From: Jackson Purcell <jackson0121@gmail.com>
Sent: Thursday, April 30, 2026 8:29 AM
To: CDS User; Bradley Gasawski
Cc: Terrence Danysh; cbeckett@prklaw.com
Subject: SE-26-00001 SEPA comment
Attachments: A-5 Easton TIA Review memo Final_with attachments.pdf

Re: SEPA Checklist and Application SE-26-00001 – Easton Travel Center (Majestic Group LLC) – Strong Opposition and Request for Denial

Subject: Easton Truck Stop Transportation Traffic Impact Analysis Review

Figure 3
 Projected 2025 PM Peak Hour
 Traffic Volumes with Project

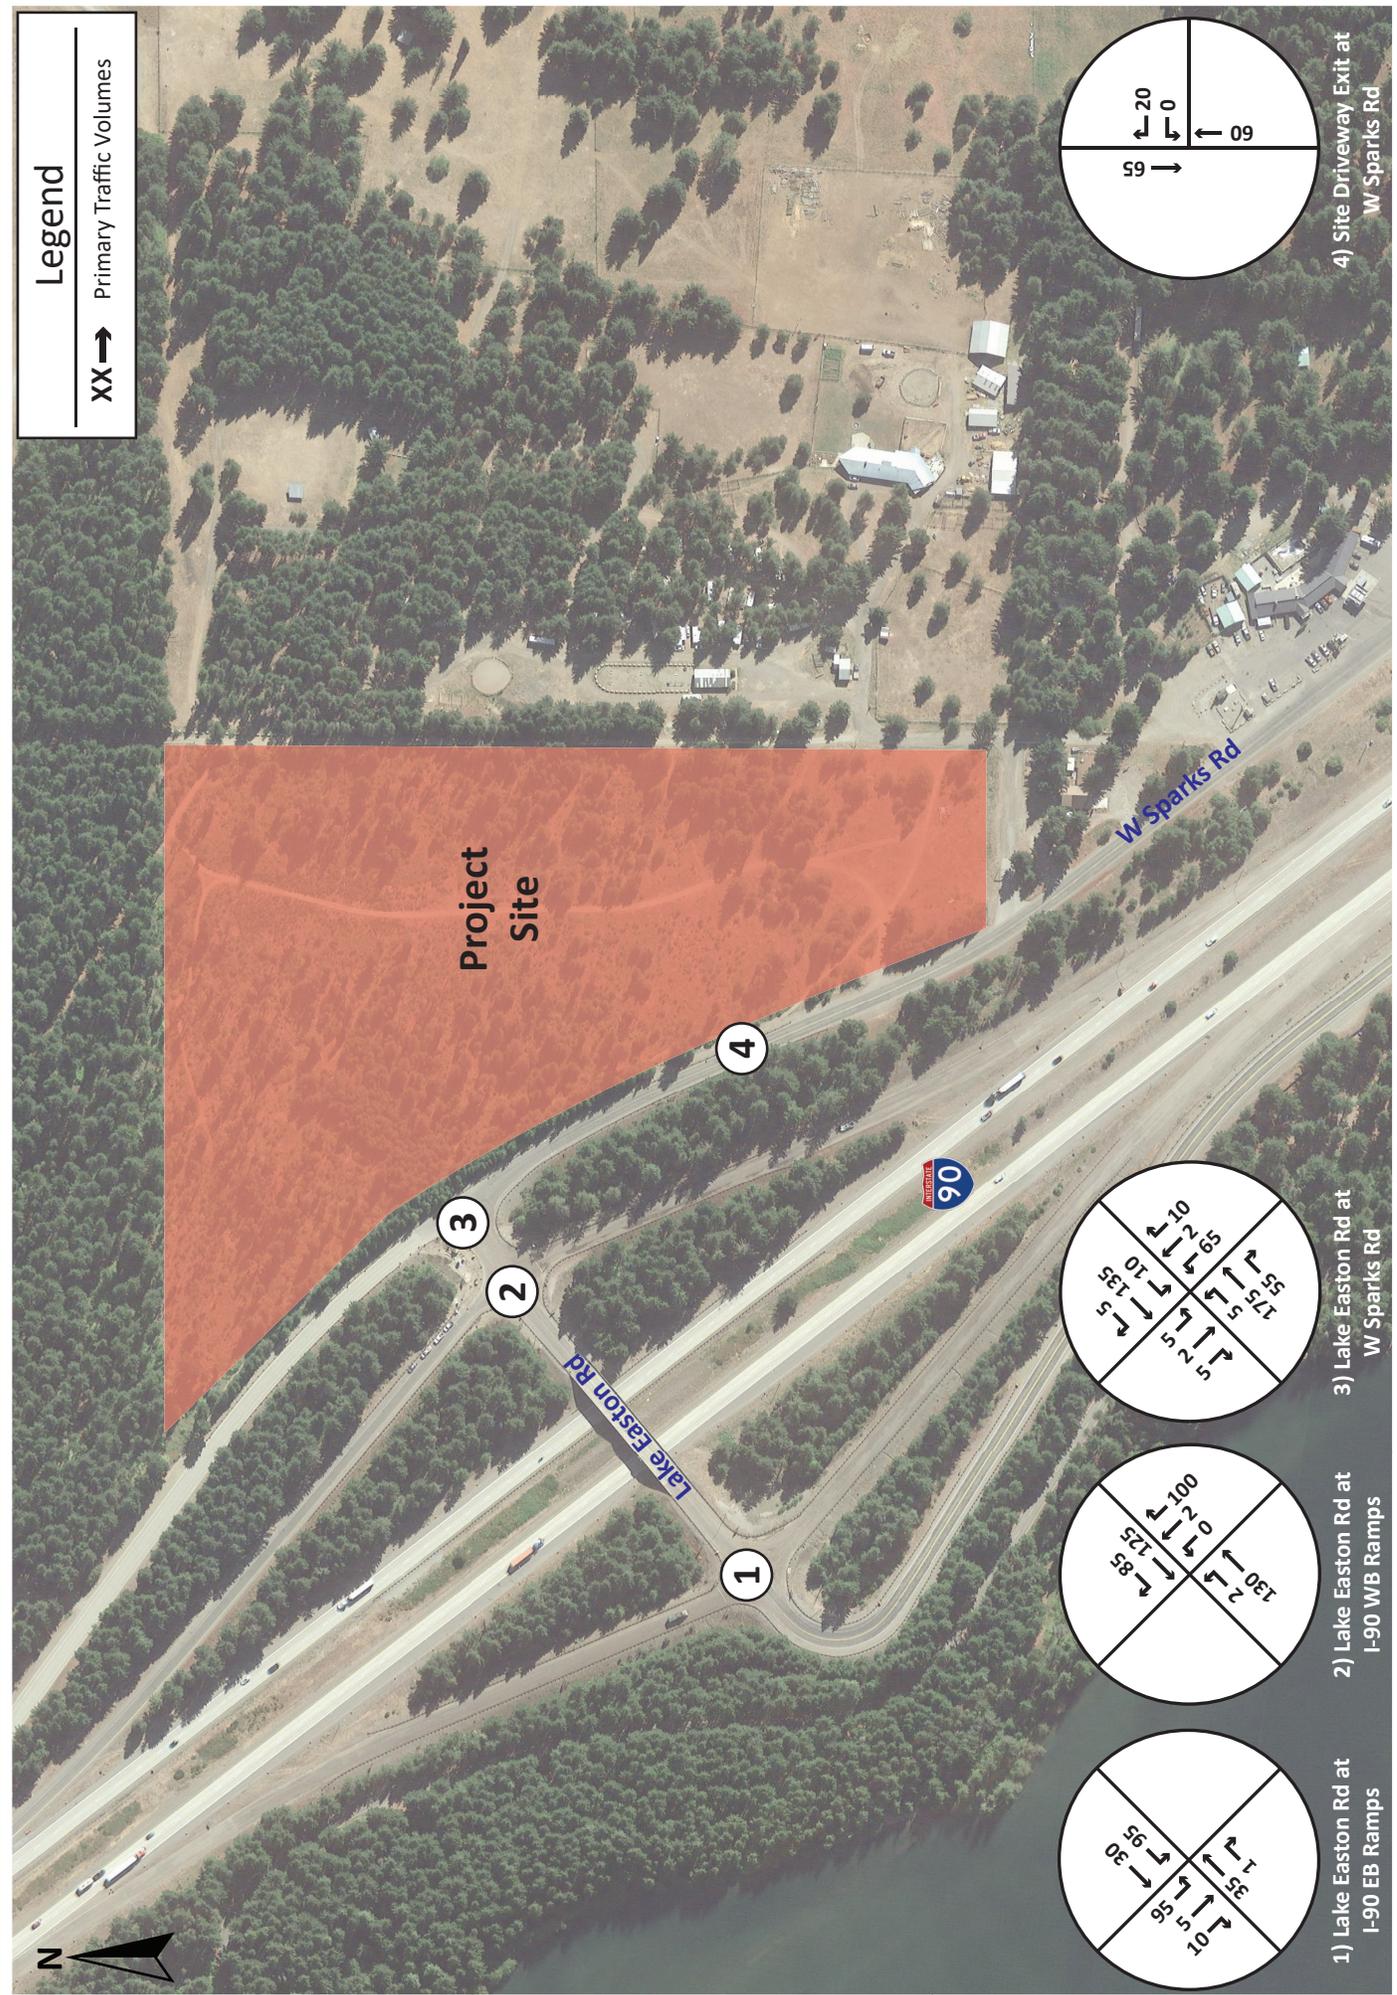
Future With-Project Volumes. Both Transpo and SCJ Alliance added two years' worth of background traffic growth to the existing volumes to forecast future without-project volumes (2025, the project opening year). Then, the trips associated with the proposed project were added to determine total with-project turning movement volumes. Table 5 summarizes total intersection volumes projected by SCJ Alliance and Transpo. The difference in traffic volumes reflect the updated counts as well as the increases in site trip generation forecasts. As shown in Table 5, as a result of updates to these two areas, the Transpo forecasts are 62% to 91% higher overall in with-project conditions.

2. From SCJ Alliance Study April 2023, Figure 3

Figure A
 PM Peak Hour Primary and Pass-By
 Site Generated Traffic Volumes

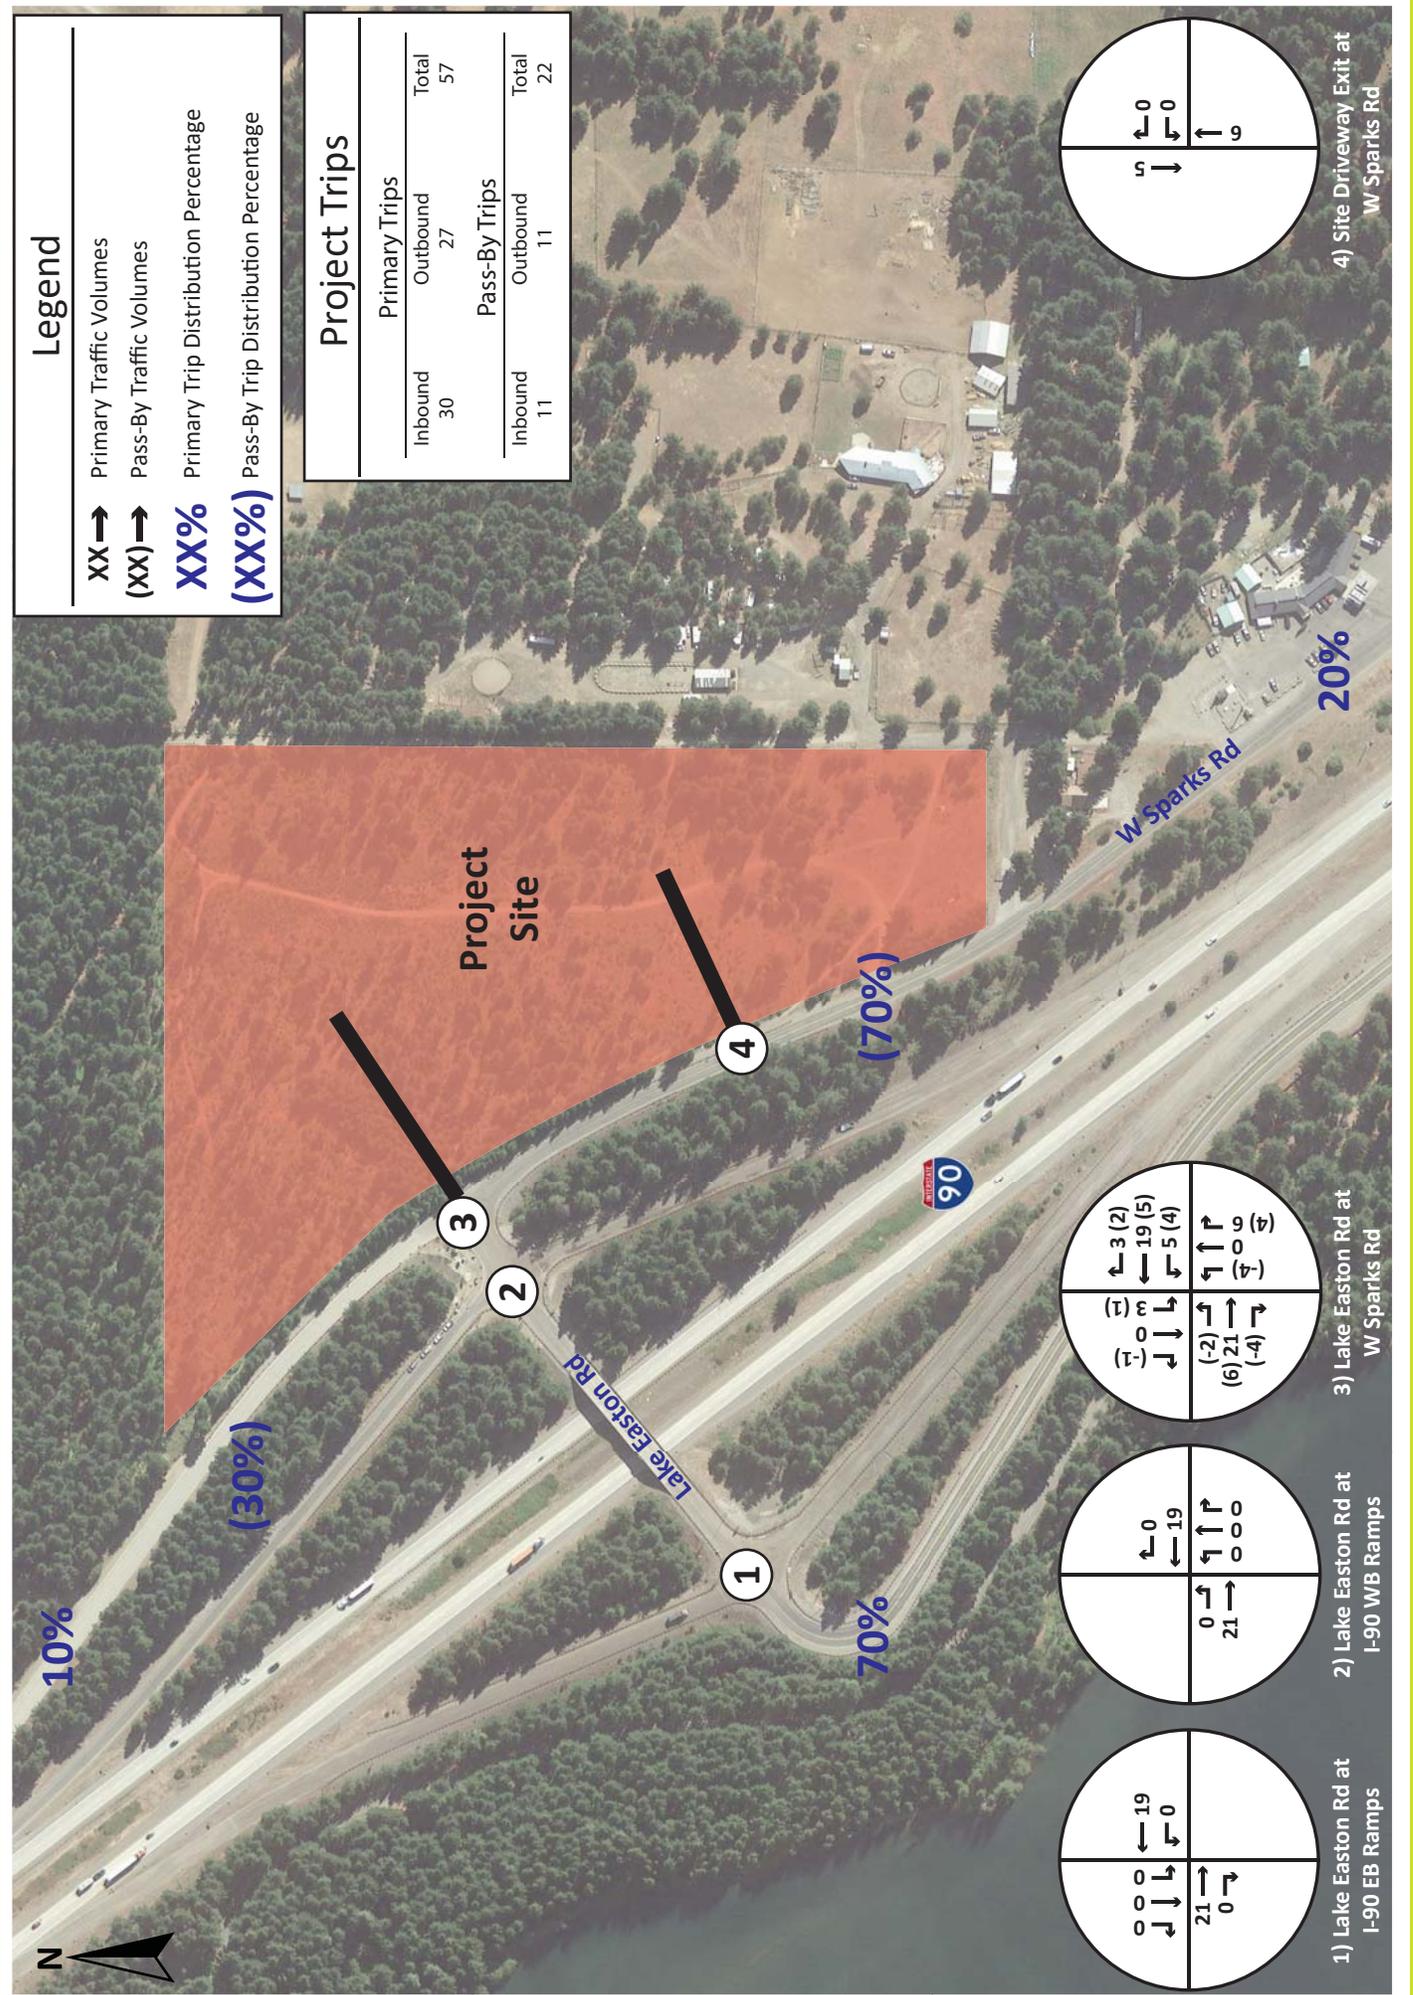
The source of trip generation in the SCJ Alliance studies is unclear. Appendix B of the August 2019 study shows a summary trip generation table. This is shown below. The yellow highlighted areas show a trip generation rate for Truck Stop LU 950. However, the SCJ Alliance report text says they relied on the City of Fontana study for a trip generation rate. That rate was 8.22 per pump. The provenance of the 22.73 rate is unknown. It does not appear anywhere in the City of Fontana study.

SCJ Alliance's trip generation table (2019 study) shows a calculation of 216 total trips in that row. The following row shows the trip generation using the 8.22 per pump rate, or 74 trips (green highlight). The next row shows, in green, 142 trips; this is equivalent to 216 – 74.

The blue highlighted areas indicate that, for Love's Travel Stop passenger cars, ITE *Trip Generation* LU 950 (Truck Stop) was used. However, that manual clearly states that LU 950 trip generation rate apply *only* to trucks, and specifically not to passenger vehicles. There is no Trip Rate given in that row, but volumes are shown.

Note that the green highlighted cells show those data used to reach a total trip generation of 358 trips in the SCJ Alliance work. That is for the entire project, not just the truck stop.
